Project Name:	Land at Bayards, Eastergate (Miller Homes)
Document Reference:	091.5016/SVR/4.2
Document Name:	SuDS Verification Report – Area 4
Prepared By:	Samuel Flesher
Checked By:	Meagan Weedon
Approved By:	Jon Soar

- 1.1 This Sustainable urban Drainage Strategy (SuDS) Verification Report – Area 4, has been prepared by Paul Basham Associates on behalf of Miller Homes to support the 'As-Built' verification report to Arun District Council in relation to Land at Bayards, Eastergate.

PBA Drawing No. 091.5016.0501 Revision C08

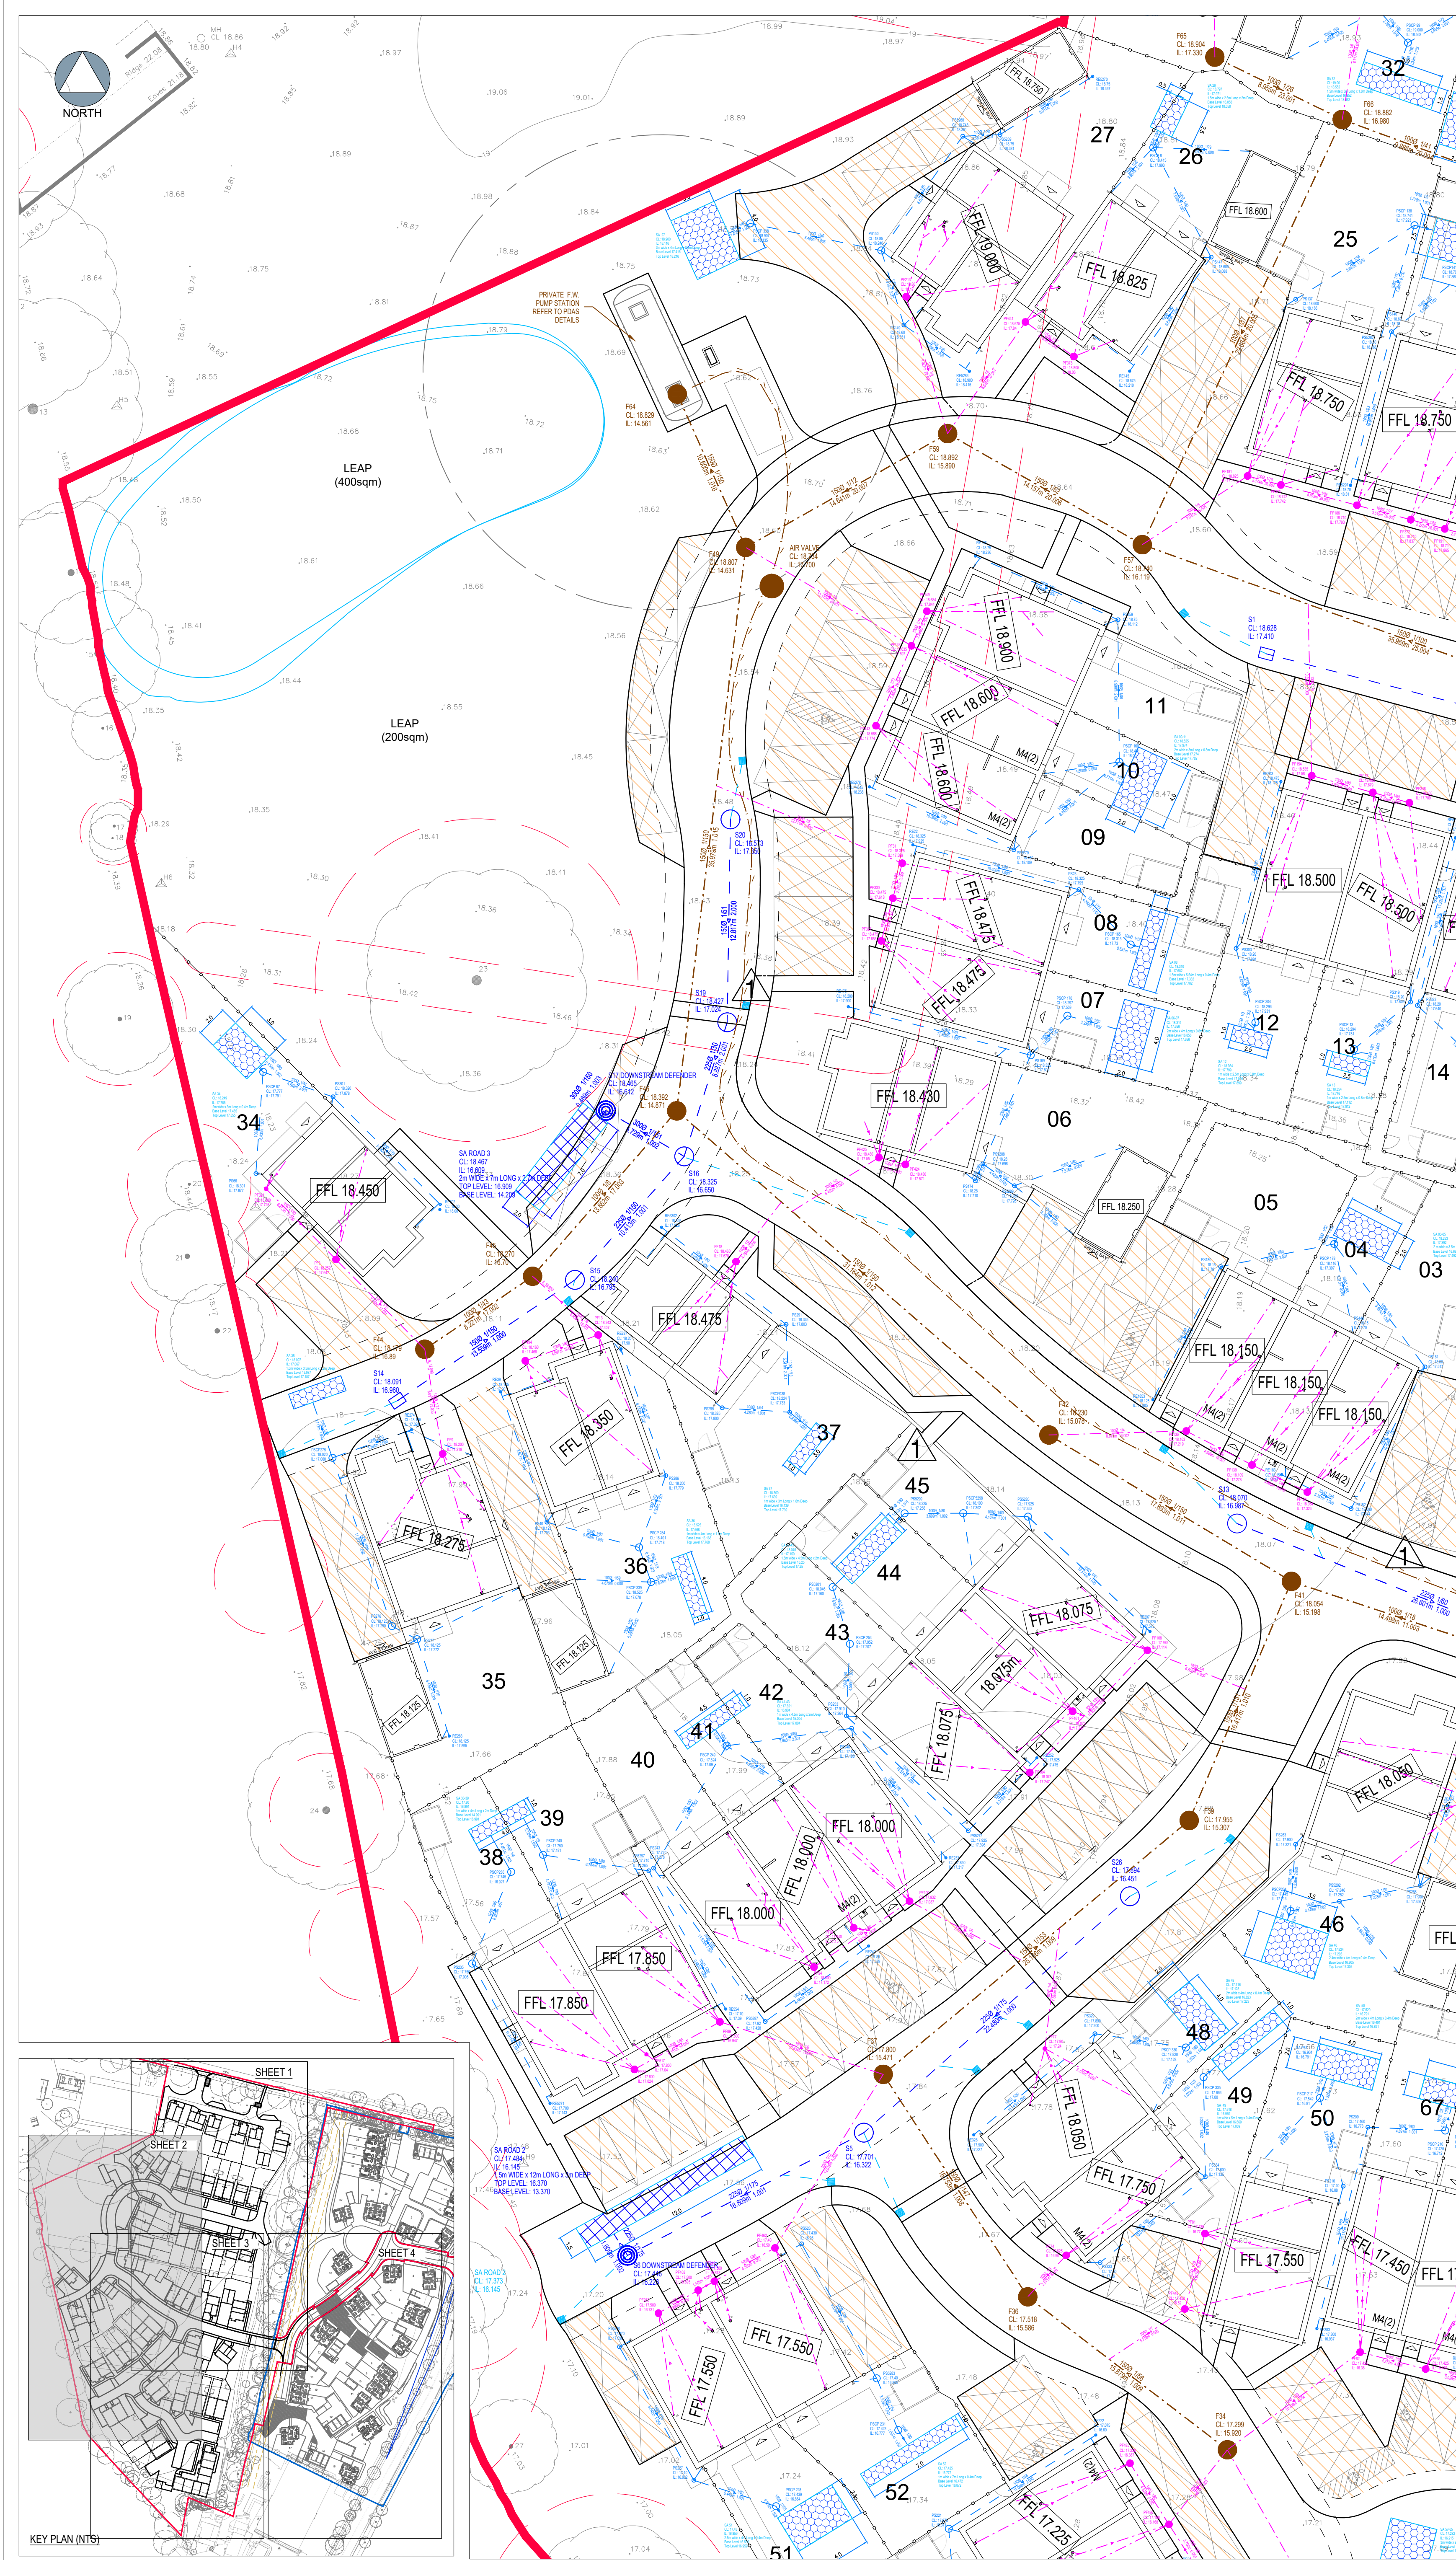
- 3.1 As-Built surveys of the site area and drainage systems have been carried out, these surveys are included as **Appendix C**.
- 3.1 These levels have been reviewed against the design levels shown in 091.5016.0501 C08, 091.5016.0502 C05 and 092.5016.0503 C06 the design drawings can be found in **Appendix B**
- 3.2 A tabulated summary of invert levels for chambers constructed within Area 4 is given below.

- 3.3 The comparison between the design and as built levels shown that the invert levels are generally within normal building site tolerances.
- 3.4 Based on the as-built levels as per Table 1 cross checks of raised invert levels appear to show that no backfalls have been created.
- 3.5 No levels were provided for SA36 and SA35, therefore we were unable to verify these soakaways have been constructed in accordance with the design.

- 7.1 The air vent to the Soakaways requires investigation and resolution.
- 7.2 Investigate the cases where the pipes may be back falling and remediate if necessary.
